Subject: FW: ABP Case ref. JA18.314501 (South Dublin Street Regeneration Project) TII Submission
Attachments: ABP Case ref. JA18.314501 (South Dublin Street Regeneration Project)

Ár dTag | Our Ref.
TII22-119970

Re. South Dublin Street Regeneration Project, Monaghan Town

ABP Case ref. JA18.314501

Scale 1:250 @ A1 1:500 @ A3	Project MONAGHAN TOWN - DUBLIN STREET REGENERATION PROJECT		
Created on JUNE 2022	Title EARTHWORKS		
Sheets 01 of 08			
File Identifier MGT0528-RPS-00-XX-DR-C-EW0001	Drawing No. EW0001	Status S4	Rev P01

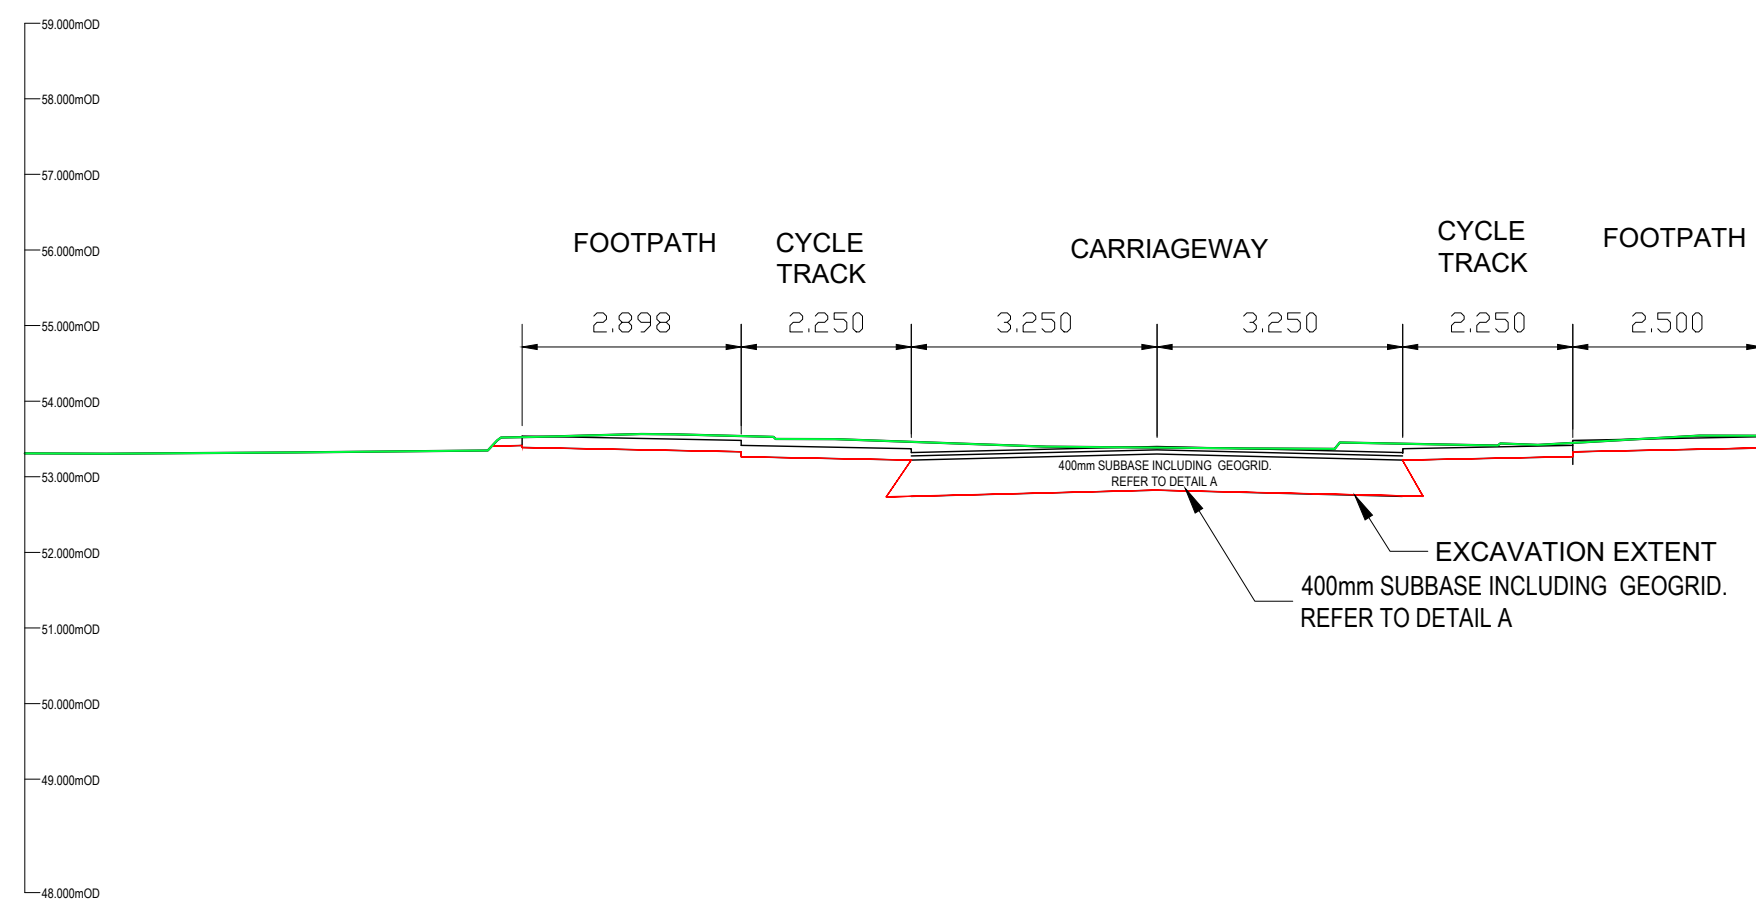
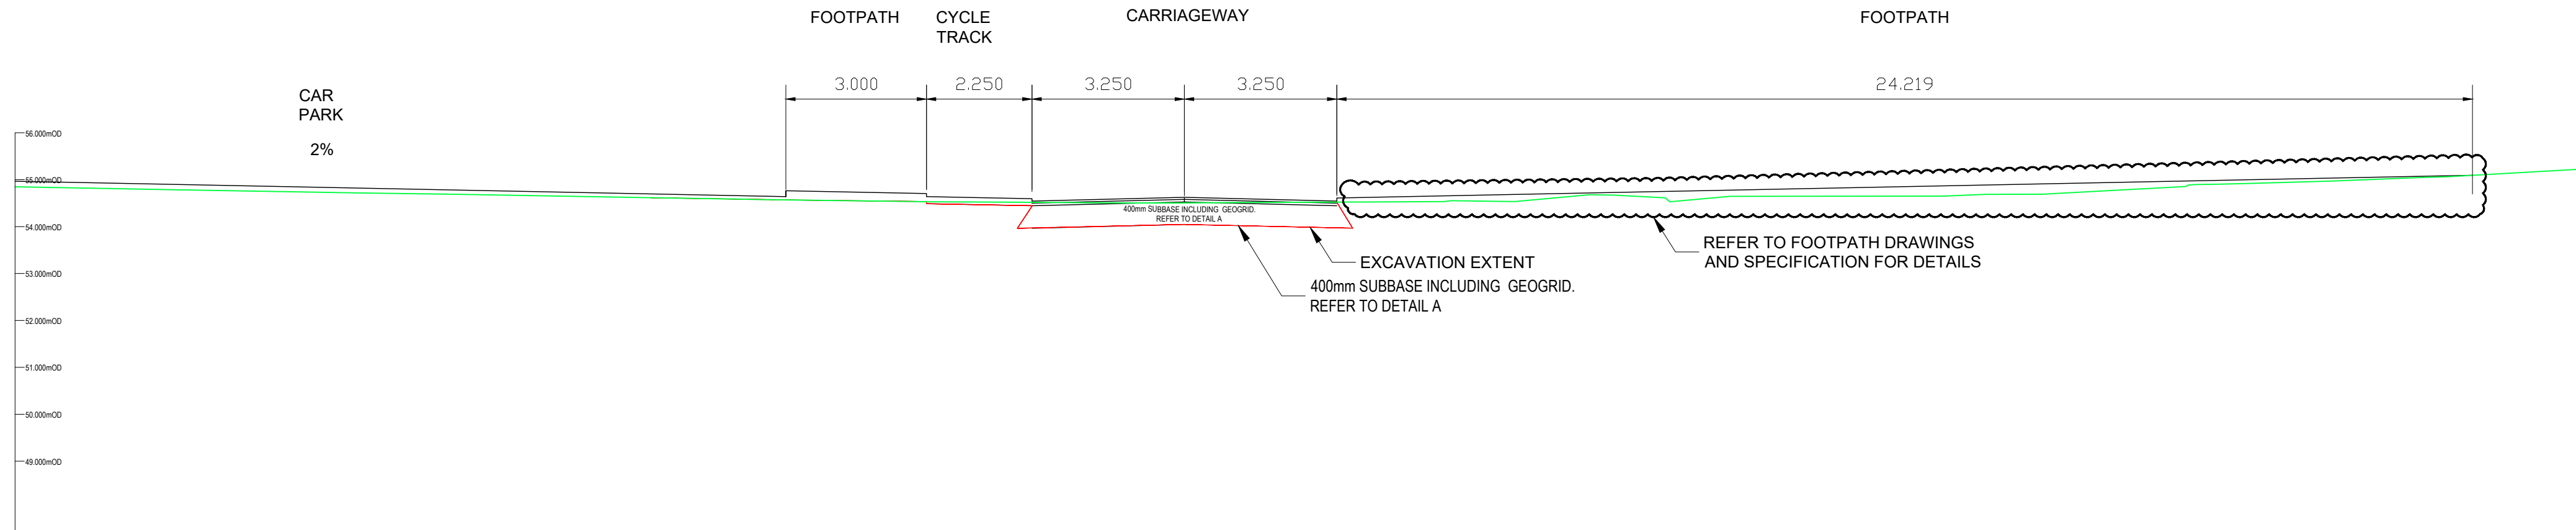
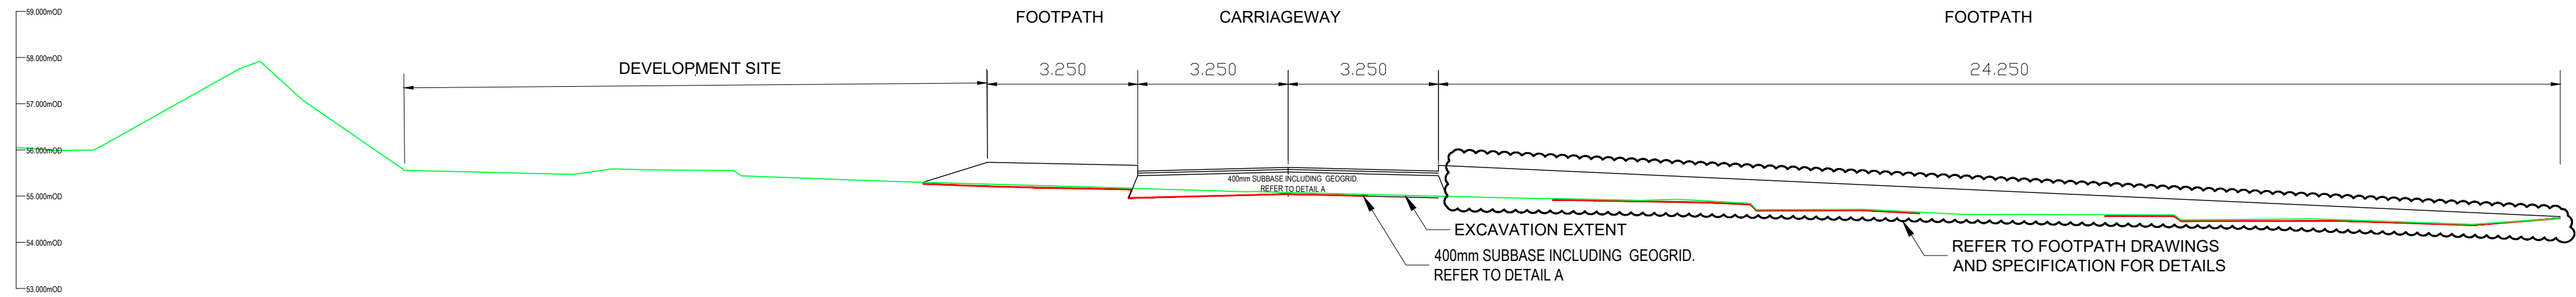
Modifications to the N54, national road, included in the subject application provide for the creation of Gavin Duffy Place and the introduction of a raised table on the adjoining section of N54, national road, at this location. The N54, national road, is a strategic national road and will continue to facilitate strategic traffic including heavy commercial vehicles, therefore, the national road pavement must continue to support this function.

In that regard, the construction of the raised table on the N54, national road, and the materials used should accord with TII Publications design specifications as well as TII Publications (Standard Construction Detail) CC-SCD-05145 (Raised Table Detail) for construction of raised tables on reduced speed limit urban national roads.

- The subject development shall be undertaken in accordance with the Design Report and Road Safety Audit and any recommendations arising shall be incorporated into the subject development for construction,
- In association with DMURS principles applying to urban roads, works to the N54, national road, shall apply TII Publications design specifications, including the Standard Construction Detail CC-SCD-05145 (Raised Table Detail) for the raised table proposed at Gavin Duffy Place.
